Contact Julia Puton
Email FRMConsultations@hertfordshire.gov.uk

Date 18 February 2021

RE: 6/2020/3222/MAJ – Former Volkswagen Van Centre, Comet Way, Hatfield, AL10 9TF

We therefore object to the grant of planning permission and recommend refusal on this basis for the following reasons.

Stantec Drawing 47179/4001/002 Surface Water Drainage Strategy

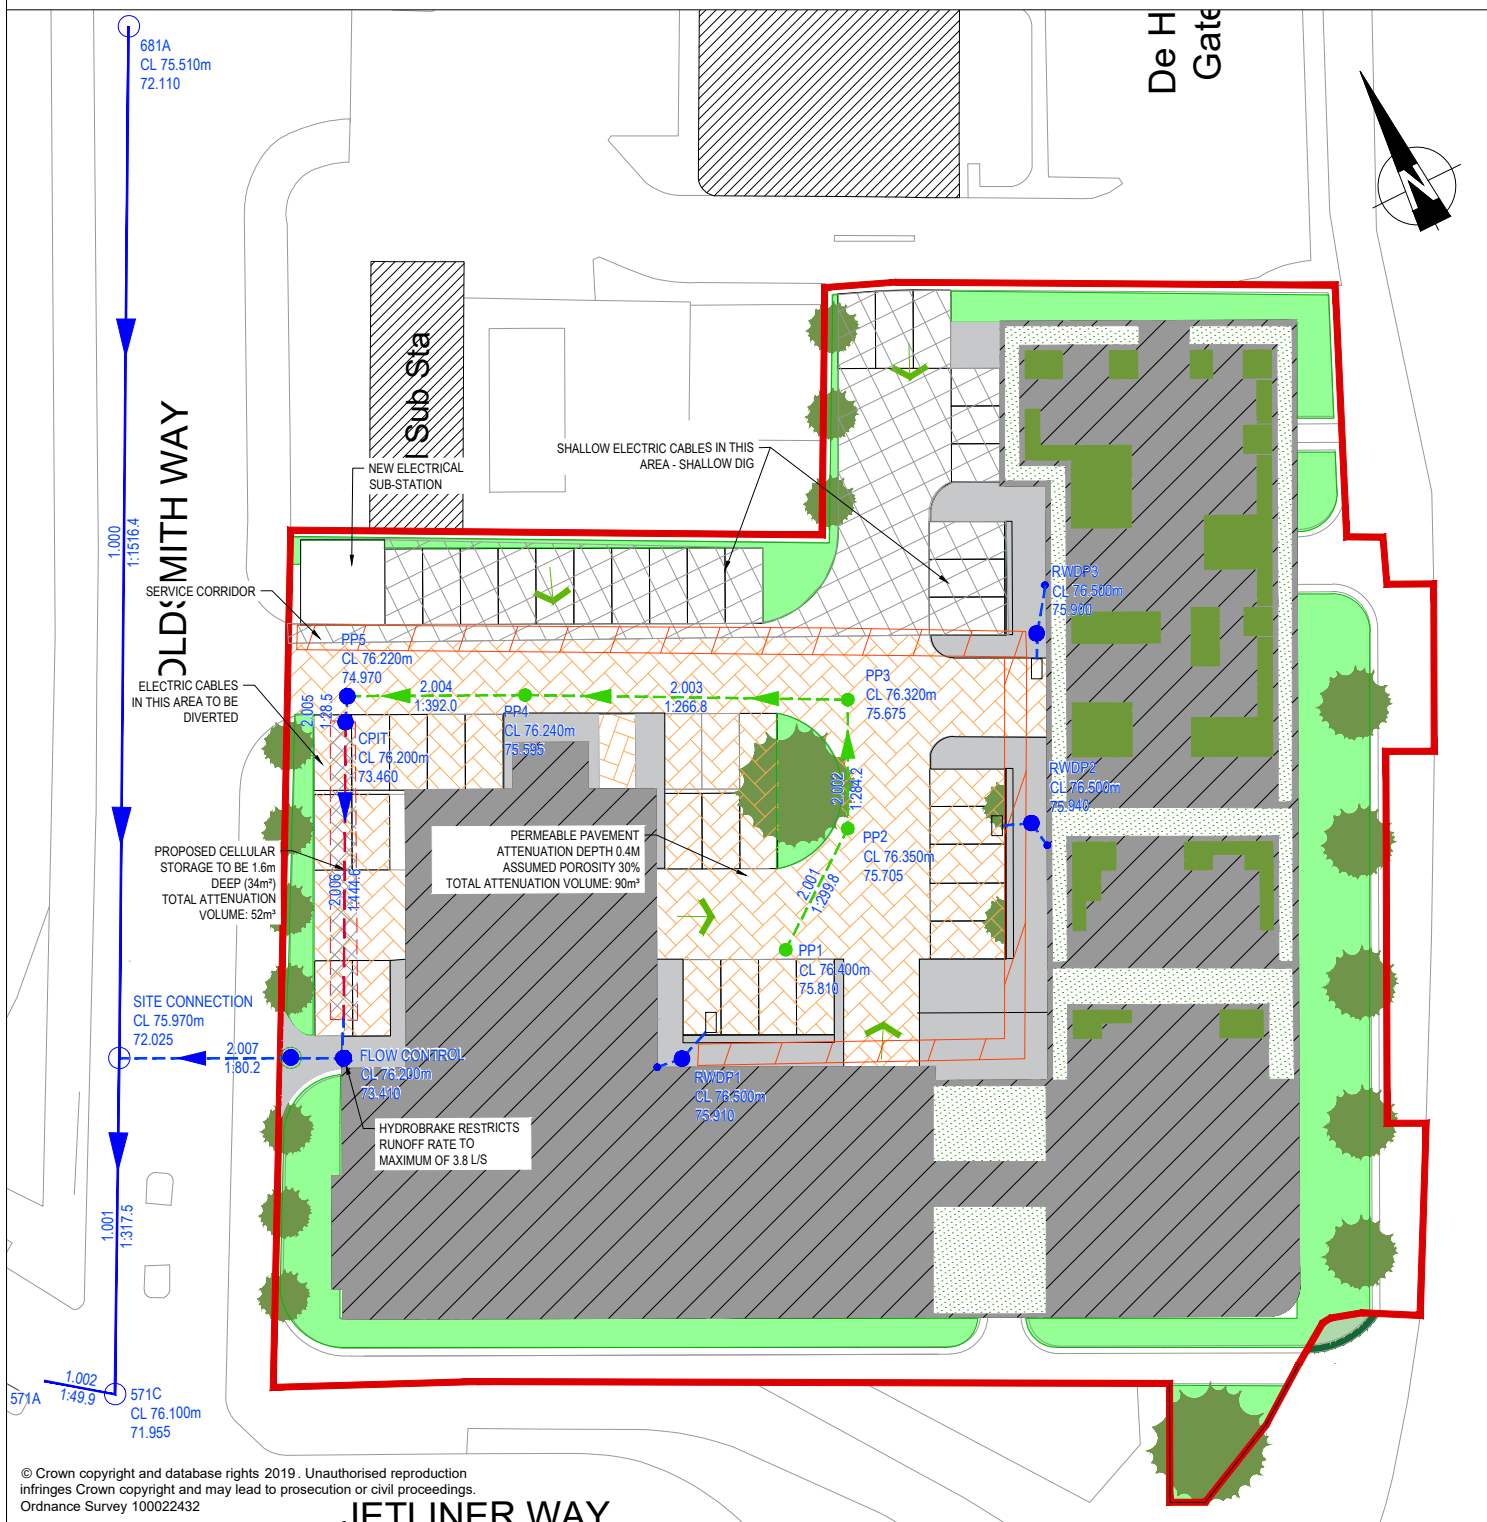
2. We note that some of car parking areas, located outside of the building footprint, will be provided with permeable paving with sub-base. However, there are some parking spaces where these structures cannot be provided. Therefore, the applicant should clarify how surface water from those areas will be captured and treated prior to reaching the piped network.

Moreover, it should be clarified and identify on a plan how the rest of undercroft parking will be drained, as no information has been provided.

As the LLFA, we are assessing surface water drainage within the application's red line boundary. Therefore, the applicant should clarify how they intend to drain new proposed footpaths around the building.

On the submitted drainage plan the proposed depth of the cellular storage does not match with the cross section drawing included. We would advise this should be consistent and the layout plan should be updated. In addition, depth of permeable paving sub-base structure should be also clarified.

Any changes based on our comments above should be supported by an updated report, modelling and an updated drainage layout. The applicant should ensure the drainage strategy report matches with the provided FRA.
